Norfolk Vanguard Offshore Wind Farm Substation Access Clarification Technical Note

Highways England Agreement In Principle

Applicant: Norfolk Vanguard Limited
Document Reference: ExA; ISH6; 10.D7.15
Deadline 7

Project:	Highways England Spatial Planning Arrangement 2016-2020	Job No:	60600479/DN052.004
Subject:	Norfolk Vanguard Wind Farm - Substations Access Clarifications Technical Note		
Prepared by:	Andrew Cuthbert	Date:	4th April 2019
Checked by:	Andrew Beard	Date:	4th April 2019
Verified by:	John Alderman	Date:	5th April 2019
Approved by:	Andrew Cuthbert	Date:	5th April 2019

Figure:	Drawing No: PB4476-008-006-005				
Revision:	Date:	Drawn:	Checked:	Size:	Scale:
04	12/03/2019	LB	RE	A3	1:10,000
03	13/02/2019	JT	RE	A3	1:10,000

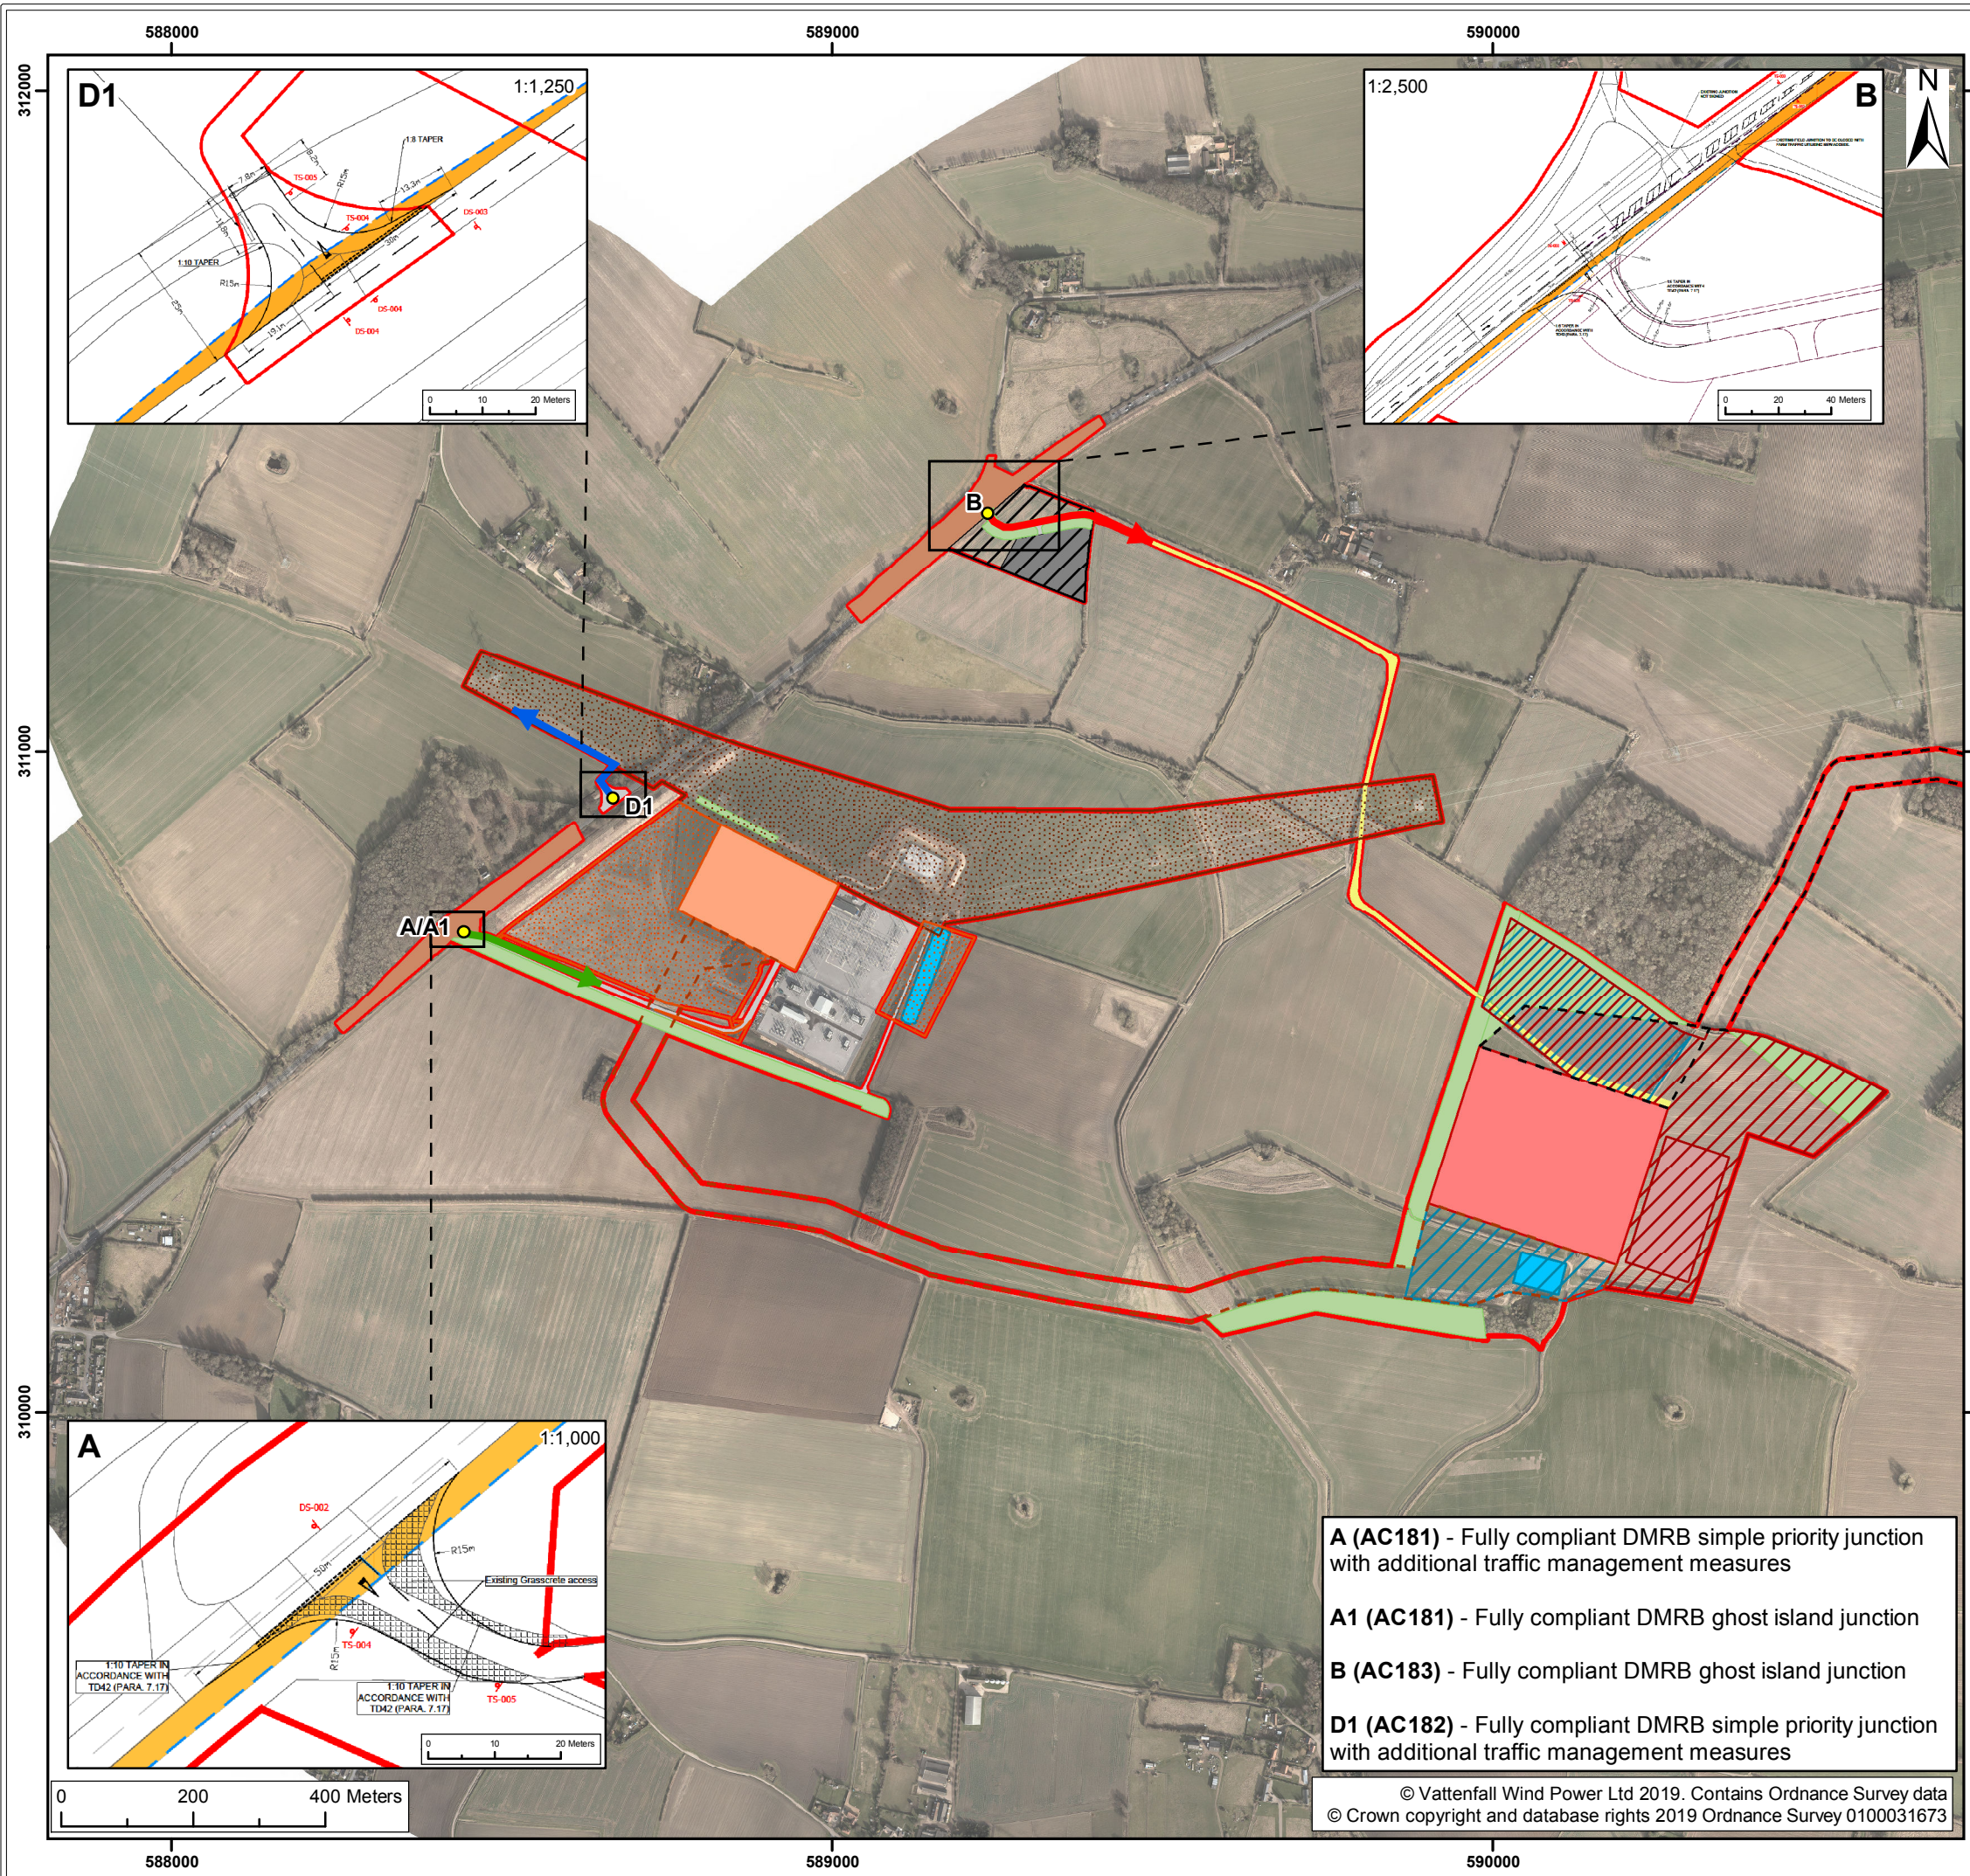
7. The SACTN contains the following material:
 - Updated layout plans for site accesses A, B and D1, including:
 - a general arrangement drawing (PB4476-008-006-005 rev 04);

10. The layouts shown on these drawings appear to have taken on board all the issues raised in AECOM Briefing Notes 04 and 06 and, with one exception, appear to meet in full the design requirements of DMRB. The exception is that the visibility to the right out of access point B can only be achieved from a position 2.4m back from the give way line. DMRB design standard TD42 permits a relaxation to 4.5m in difficult circumstances for lightly trafficked simple junctions and to 2.4m in exceptionally difficult circumstances.

11. The SACTN contains a statement that *'Increasing the 'x' distance to 4.5m would require the removal of a large proportion of established hedgerows, vegetation and trees. This will have ecological impact and would remove much of the native mature screening required to mitigate the landscape impact'*. In the circumstances, this appears to be sufficient grounds to permit what is effectively a two-step permitted relaxation in the provision of emerging visibility at access point B.

13. On that basis, the layouts currently offered for access points A, B and D1 appear satisfactory, subject to:
- visibility splays being cleared of foliage;
 - visibility being proven in the vertical plane;
 - the implementation of the traffic management measures proposed; and
 - the carrying out of Stage 1 and 2 Road Safety Audits.

15. The updated layouts, traffic management arrangements and traffic flows presented in the SACTN provide sufficient confidence to allow AECOM to advise Highways England that they could now form the basis of an updated Statement of Common Ground indicating Highways England's agreement in principle with the access arrangements proposed.
